**Re: Tempus Street Rouse Hill Mixed Use BTR Development**  
**SSD-76190964**  
**GPT Submission**

We are writing to Department of Planning, Housing & Infrastructure (DPCI), as neighbouring landowner, to provide our comments and raise concerns with respect to the above-mentioned State Significant Development Application (SSD-76190964).

project
TEMPUS STREET ROUSE HILL
 Tempus Street, Rouse Hill, NSW
 drawing
 drawing no. **DA0100** revision **P.04**

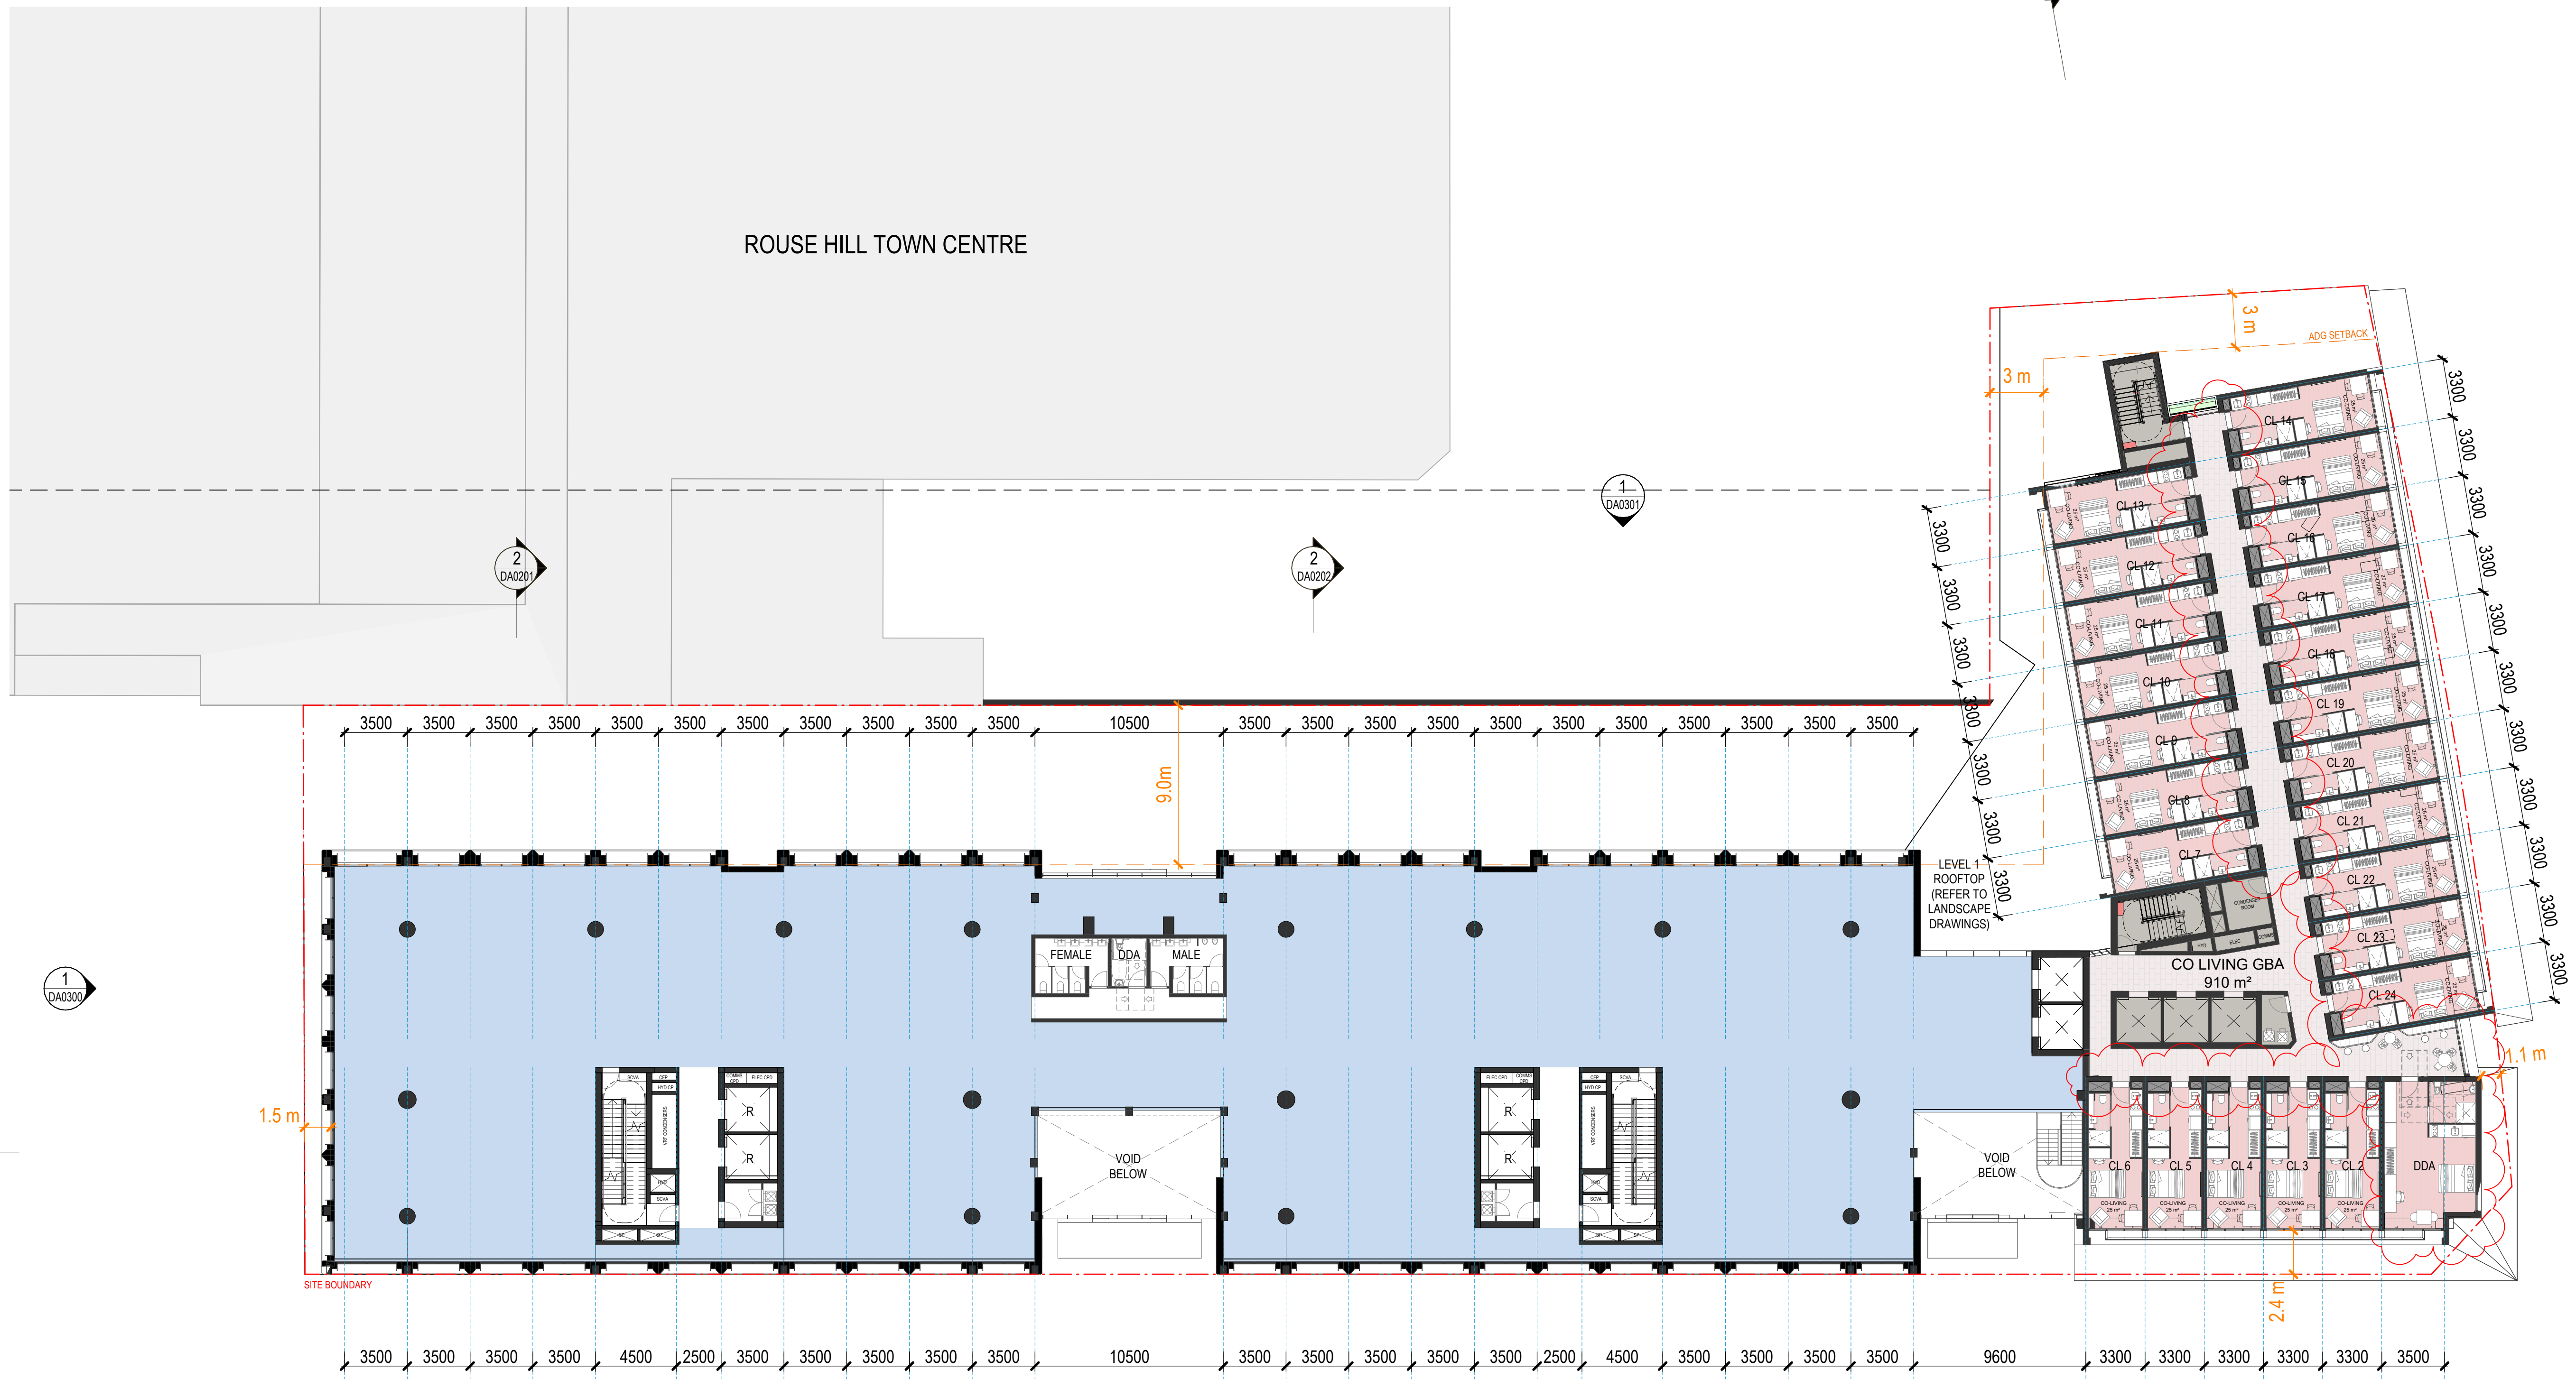
- b. Loading Dock No. 4/5 (Coles): one of our key operational loading docks is directly to the east of the proposed development. Based on the SSDA architectural plans, the proposed Build to Rent and Co-Living Units will overlook the loading dock. There should be no operational constraints placed on GPT, or its Tenants, to the detriment of the approved use of the loading dock.

- d. Proposed basement car park driveway access: the proposed basement car park access is in close proximity to the adjacent loading dock entry / exit. For safety reasons, greater separation should be provided from the proposed car park driveway entry to the existing loading dock entry / exit driveway. Furthermore, clarity is required with regard to adequate signage provisions as part of the proposed Development, to avoid its residents and tenants entering the existing loading dock.
